**DELEGATED DECISION FOR APPLICATION FOR CERTIFICATE OF  
LAWFUL DEVELOPMENT**

Reference no.: 2026/CL/90886/E

Site: 6, Pickles Lane, Skelmanthorpe, Huddersfield,  
HD8 9EJ

Description: Certificate of lawfulness for proposed single storey  
rear extension

Rev	Date
Drawing Proposed Plans and Elevations	
Drawing no:	Rev Date Scale @ A3
0163/2026 - 02	1:100 / Feb 26 1:250
Client Mr & Mrs Medcalf	
Job title Extensions and Alterations 6 Pickles Lane, Skelmanthorpe, Huddersfield

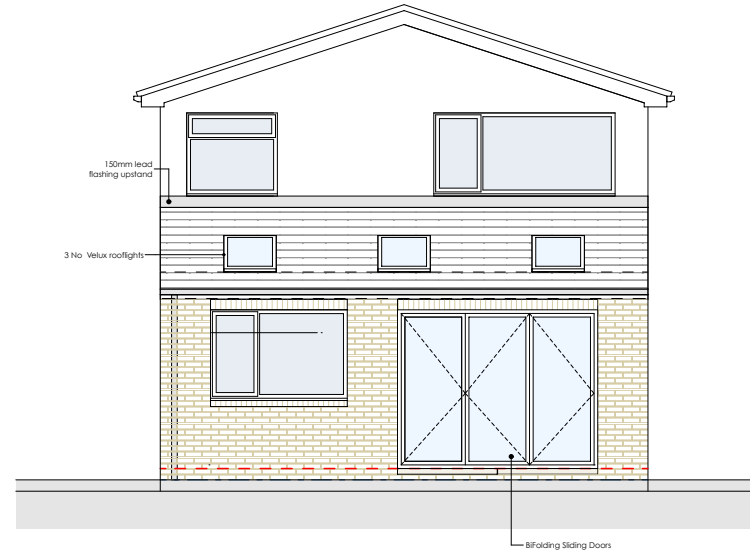
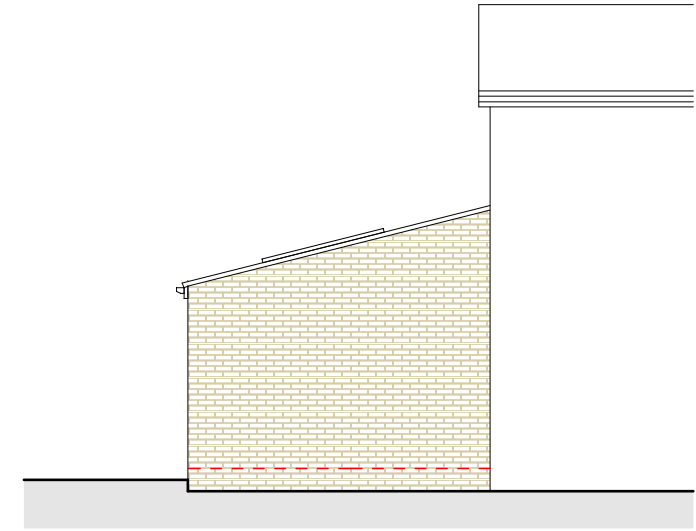
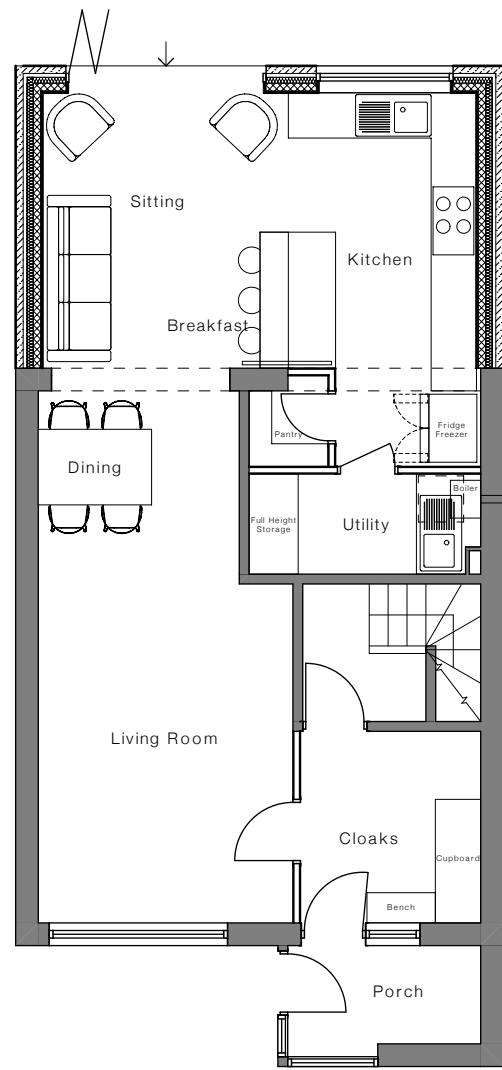
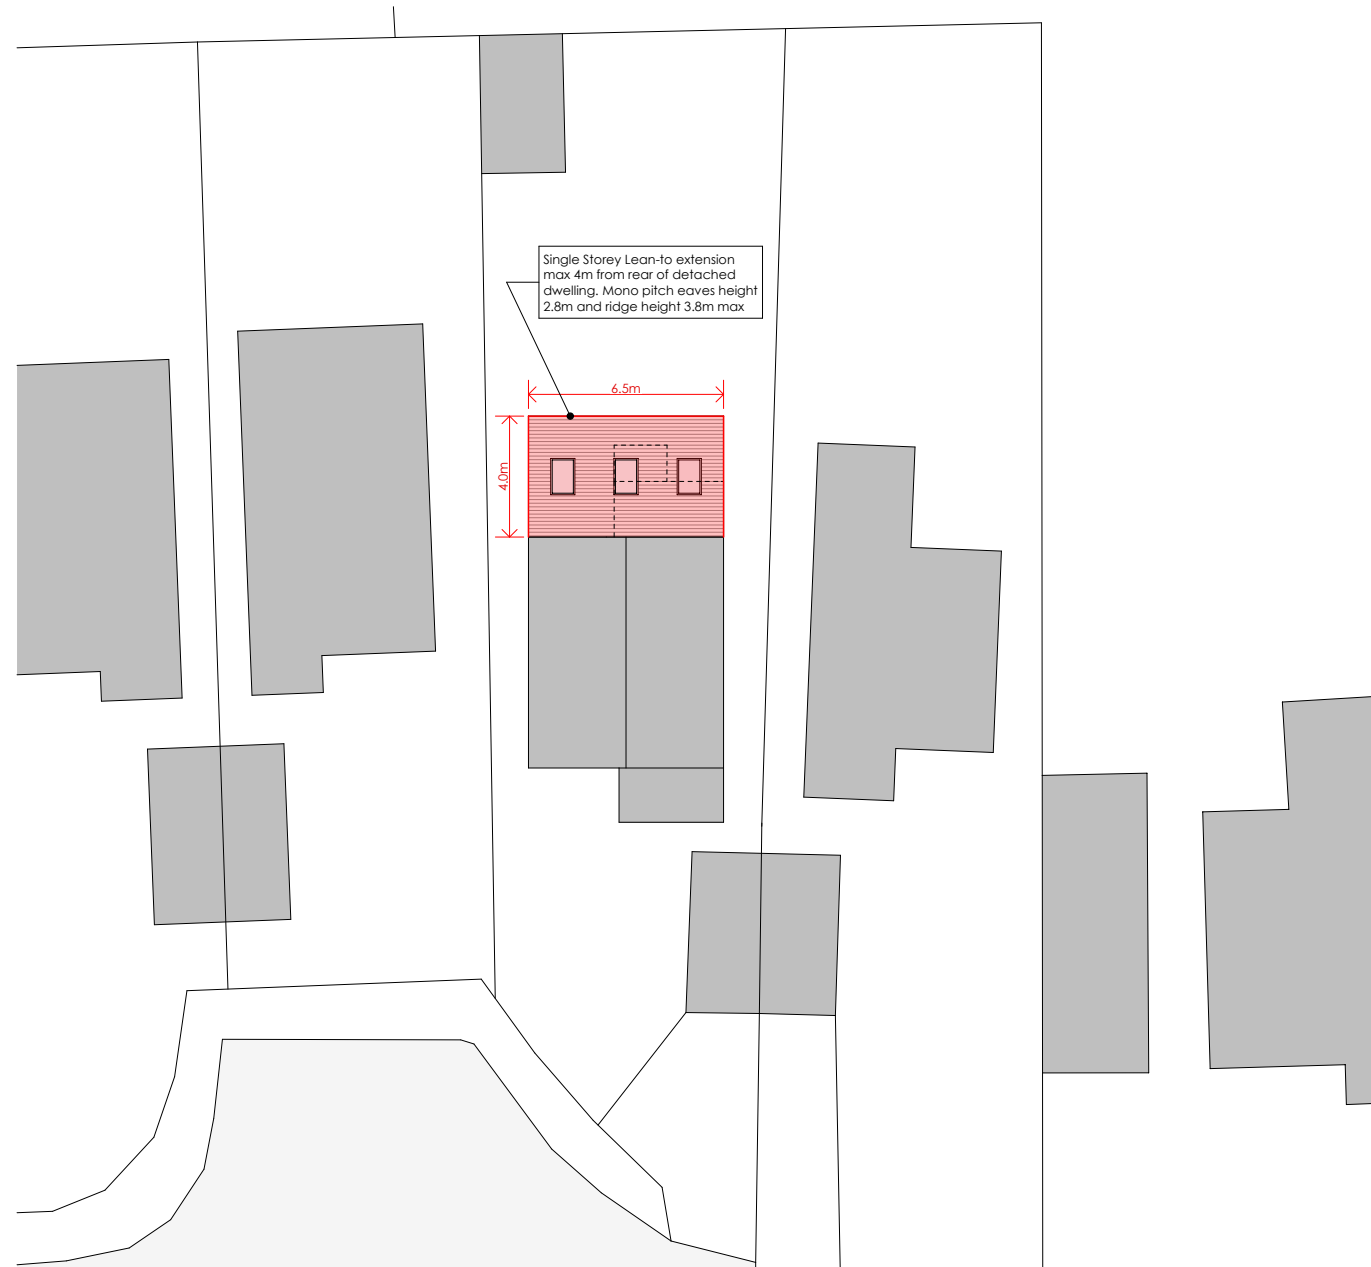
The proposed extension would replace the existing and would span the full width of the rear elevation, projecting 4 metres. The eaves height would be 2.8 metres with an overall height of 3.8 metres to the ridge of the lean-to roof.

***Comment:*** *The height of the highest part of the enlargement would not exceed the highest part of the roof of the existing dwellinghouse.*

***Comment:*** *The height of the eaves of the enlargement would not exceed the height of the eaves of the existing dwellinghouse.*

**Comment:** *The enlarged part of the dwellinghouse would extend beyond the rear wall of the original dwellinghouse and would not extend by more than 4 metres and would not exceed 4 metres in height.*

**Comment:** *The dwellinghouse is not on article 2(3) land and the enlarged part of the dwellinghouse would extend beyond the rear wall of the original dwellinghouse. It would not extend by more than 8 metres and would not exceed 4 metres in height.*

**Comment:** *The enlarged part of the dwellinghouse would be within 2 metres of the boundary of the curtilage of the dwellinghouse however the height of the eaves would not exceed 3 metres.*
